## RE “NERINGAH” SENIORS HOUSING AND HEALTH FACILITY (SSD-45121248) SUBMISSION

We refer to the above State Significant Development Application (SSD) submitted by Hammondcare at No 2-12 Neringah Avenue South, Wahroonga (referred to as No 4-12 Neringah Avenue in the application).

We are writing on behalf of the Owners of **Strata Plan 100500** known as the “**The Sirius**” apartments at 14-18 Neringah Avenue South, Wahroonga. Our client’s property directly abuts the northern boundary of the subject site. Refer to **Figure 1** below.

DRAWING TITLE
Tree Planting Plan - Roof

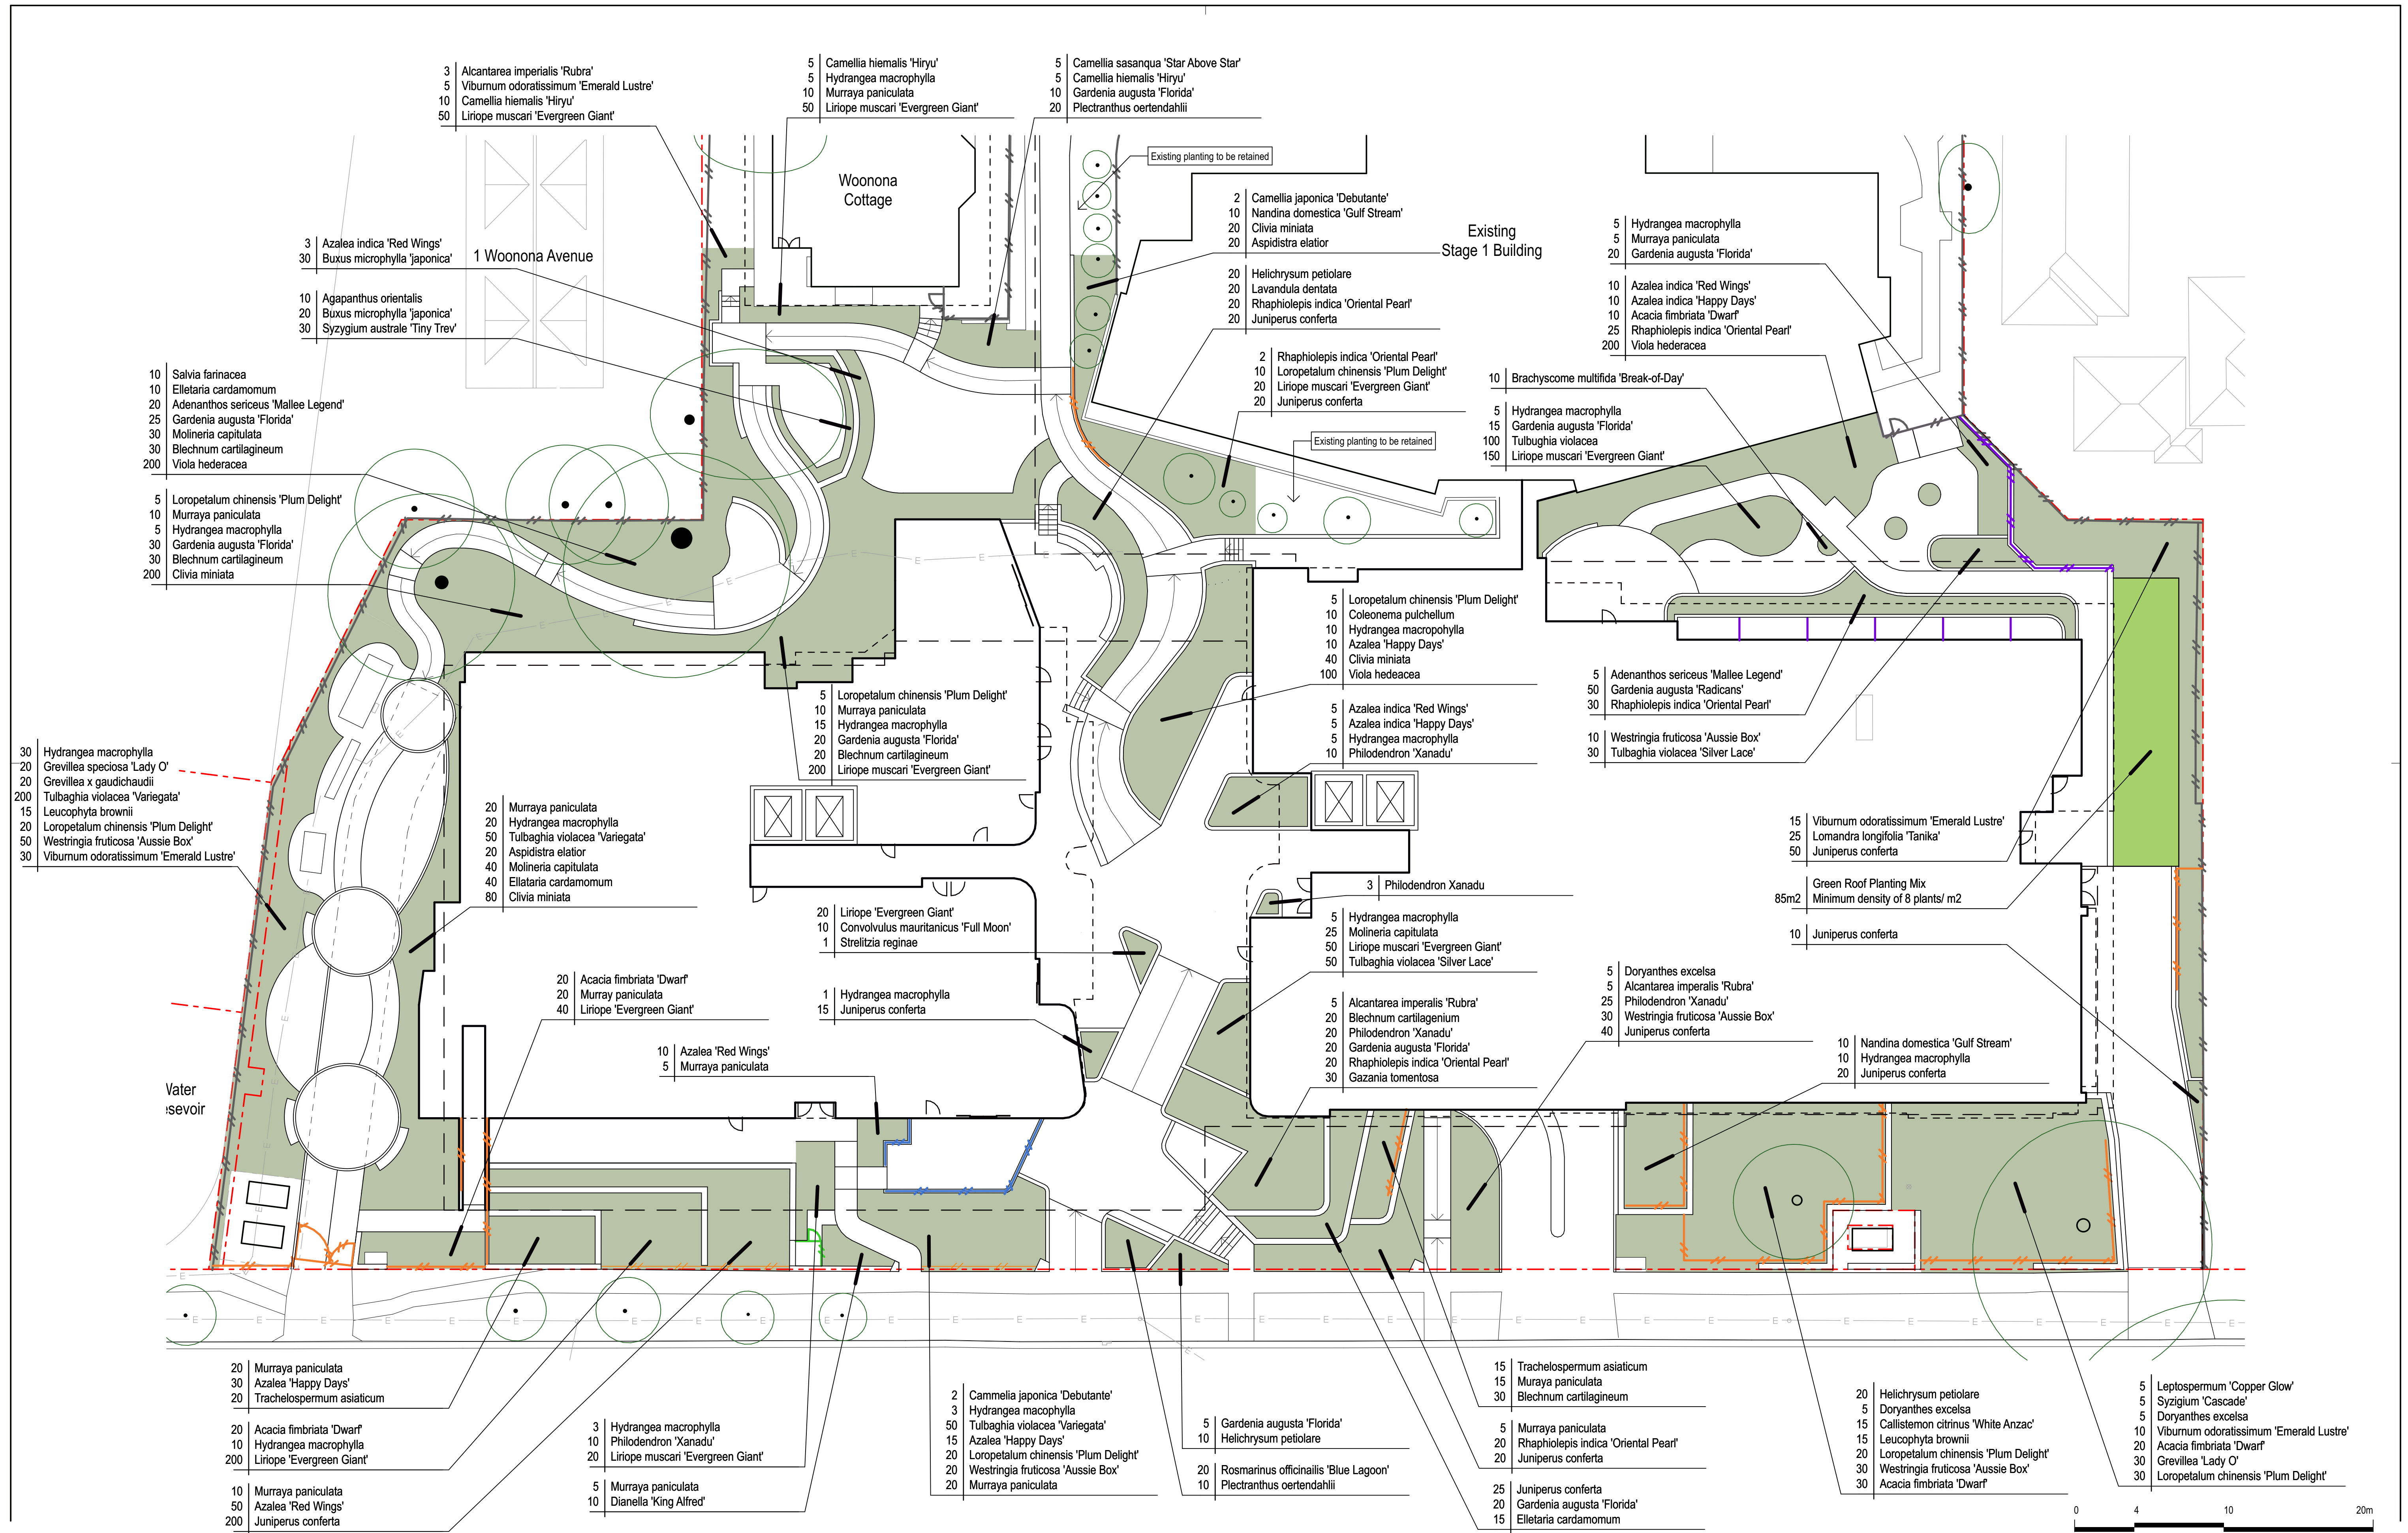
- e. **Landscape Treatment:** - The basement entry structure “lid” is shown on landscape plans to comprise “*Shallow light weight soil with hardy perennial native meadow planting over loading dock/driveway roof at lower level*” as denoted in **Figure 8**. Hence the side setbacks behind the building line which are ordinarily 6metres wide deep soil planting zones to provide tall vegetative screening between RFB developments in Ku-ring-gai, is not provided to any meaningful/effective degree.

### 9.38m Laundry Truck Driveway Swept Paths

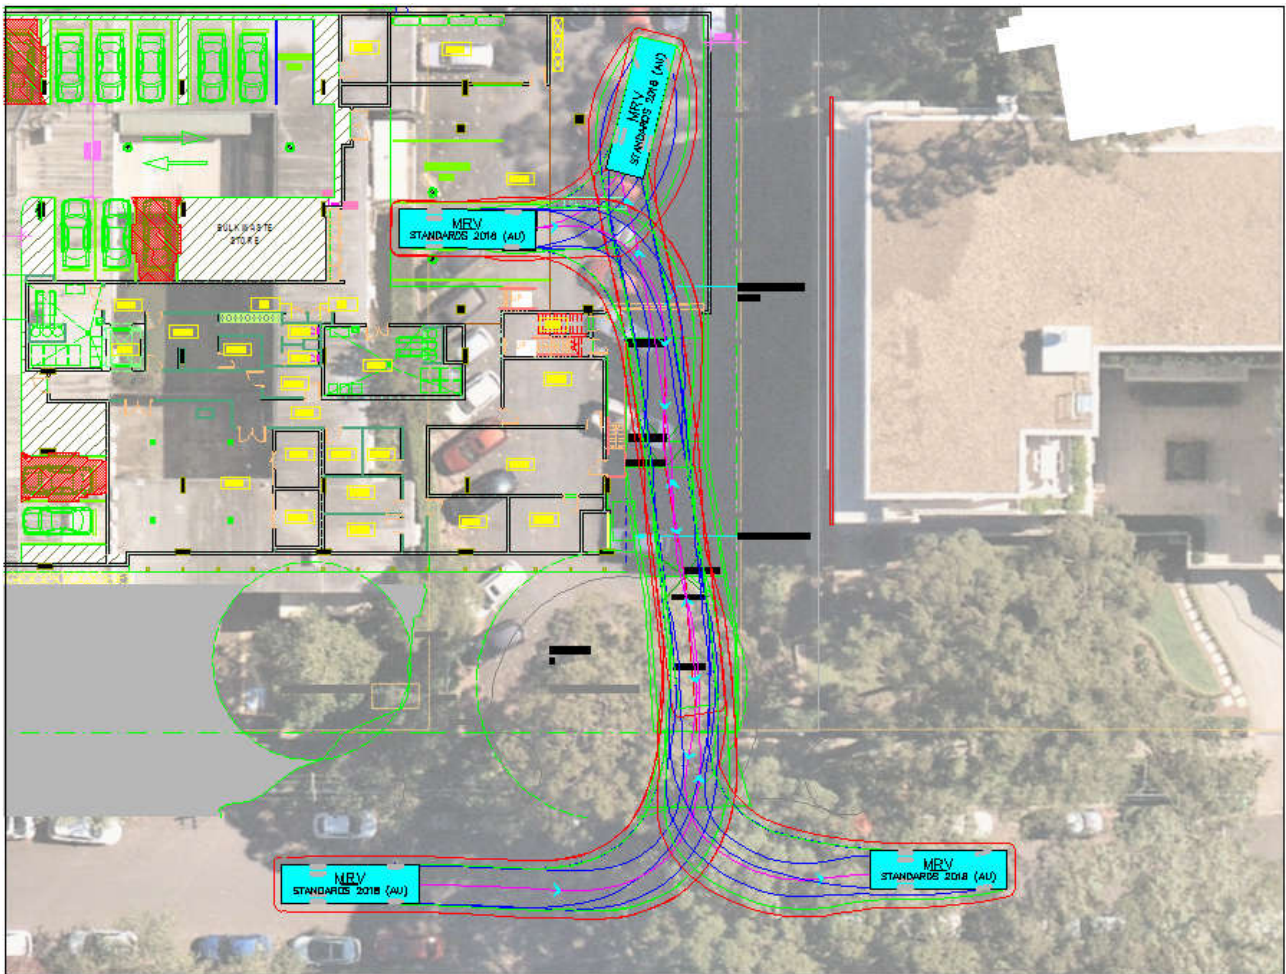
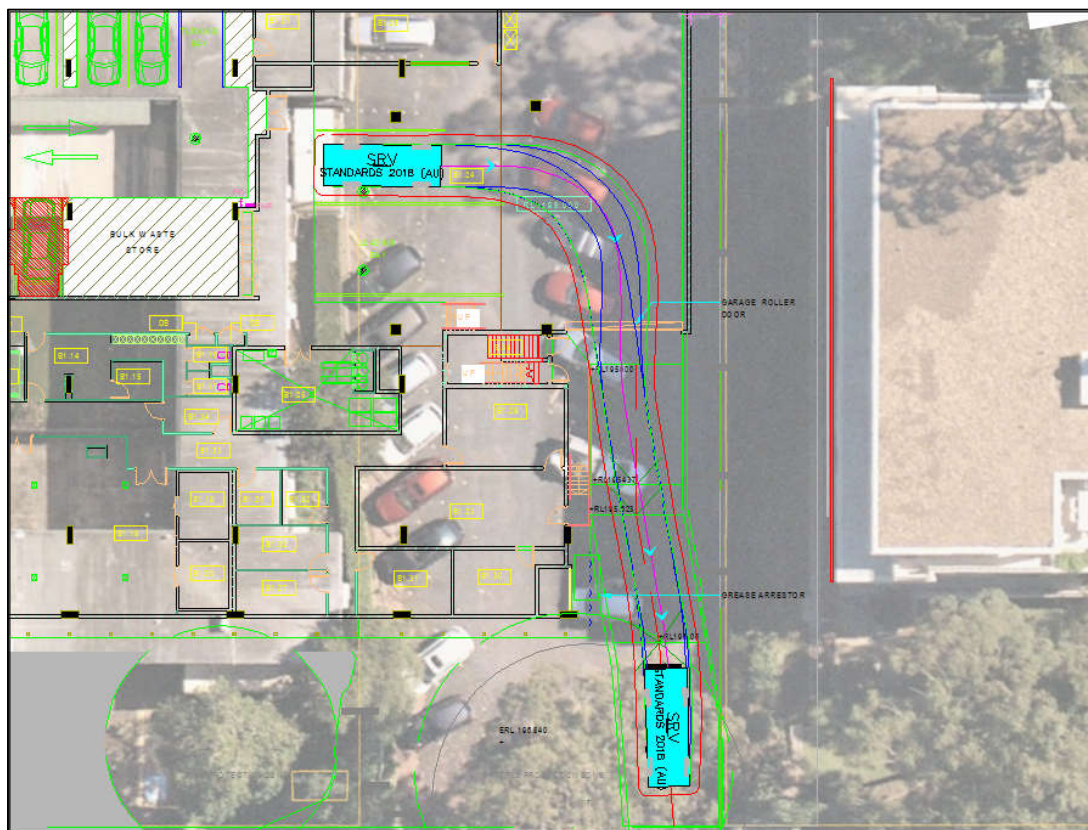
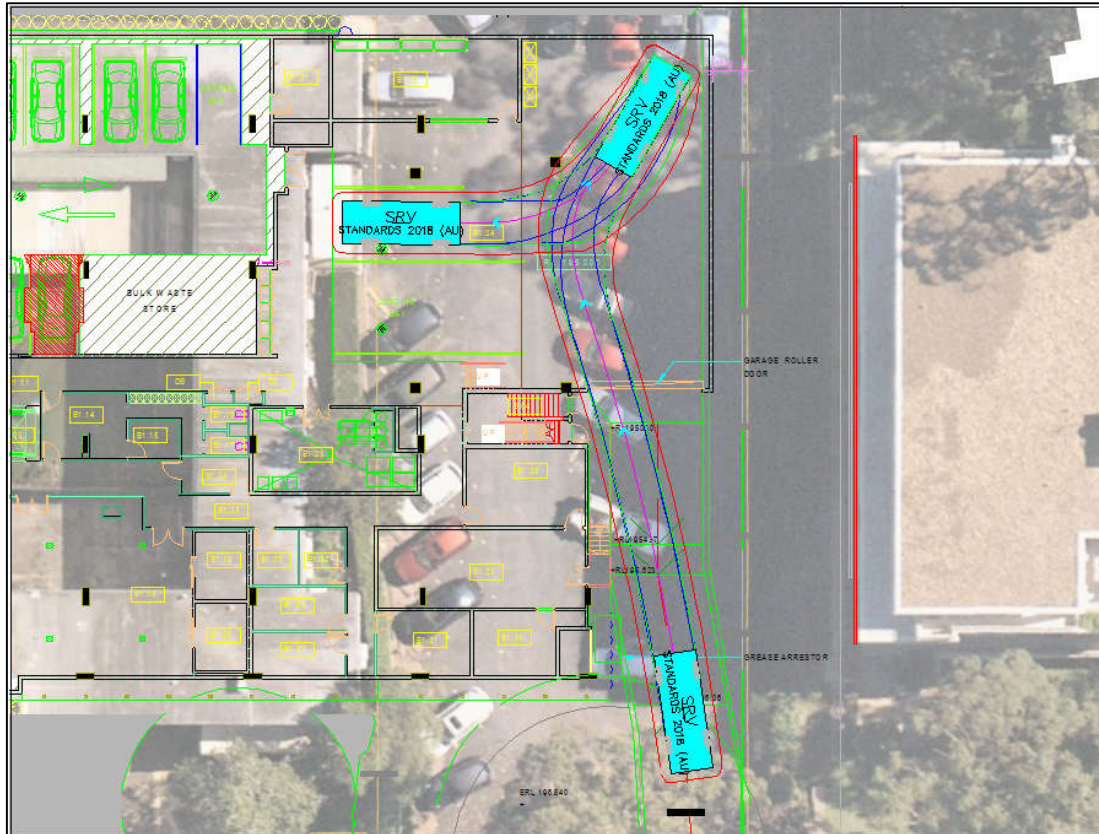
The above Annexure E *Swept Path Testing* to the submitted Traffic Report illustrates the ramp grades do not accommodate 8.8m Medium Rigid Vehicles (MRV). It is further noted that the ramp testing did not include Hammondcare’s larger **9.38m length laundry trucks** which would presumably also fail the test.

**Clarification of what changes might be required to facilitate ingress/egress of 8.8m and 9.38m trucks along the service vehicle driveway ramps is requested to be provided by the applicant to assess the redesign incase it has detrimental knock-on effects.** Provision of workable driveway design should be assessed at DA stage (not CC stage) given the driveway is immediately adjoining No 14-18 boundary and any adjustments could result in additional impacts.
